Town & Country Planning Act 1990 (as amended)
Town and Country Planning (Development Management Procedure) (England) Order 2015
Application for approval of details reserved by condition imposed under BR/54/16/PL relating to
condition No. 7 (Construction management plan), 10 (Surface water drainage), 12 (Watercourse), 14
(External lighting scheme), 15 (Noise), 16 (Public sewers), 17 (Foul & surface water sewerage
disposal), 18 (Cars), 19 (Roof plant), 23 (Landscaping scheme), 24 (Tree retention & protection plan),
25 (Programme of archaeological work & scheme of investigation), 26 (schedule of materials) & 34
(Programme of ecological work)
University of Chichester Upper Bognor Road, Bognor Regis,

Condition Number 17

Arun District Council have decided to **REFUSE** details reserved by condition for the following reasons:

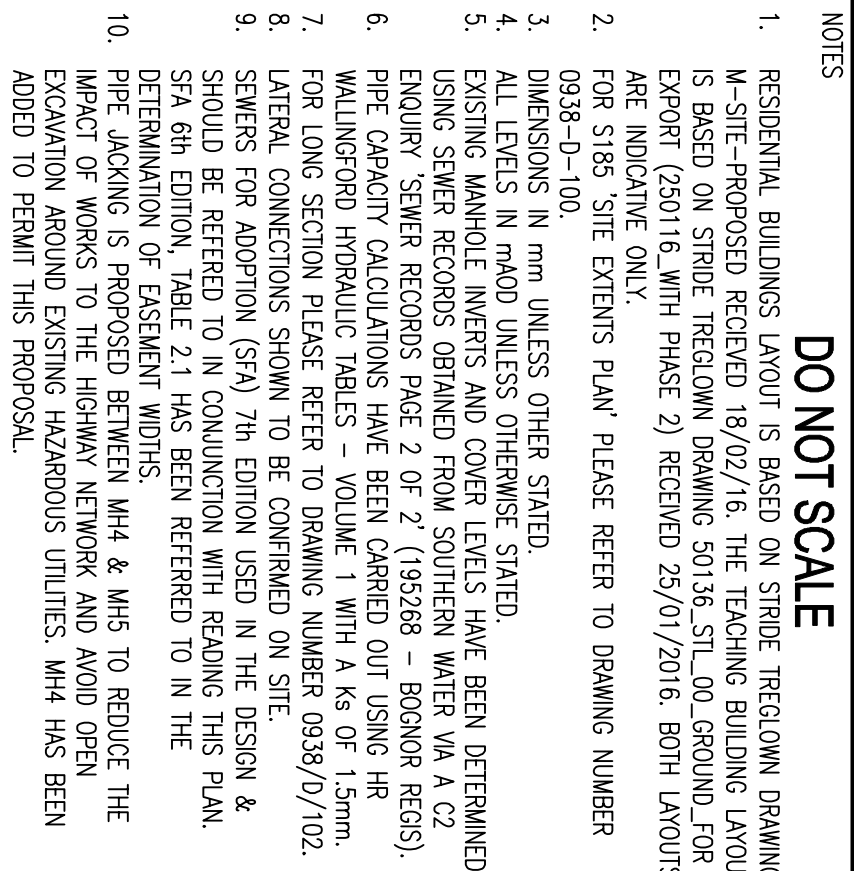
The sewer diversion proposals should be agreed and approved by Southern Water under s185 of the Water Industry Act before condition 17 can be discharged.
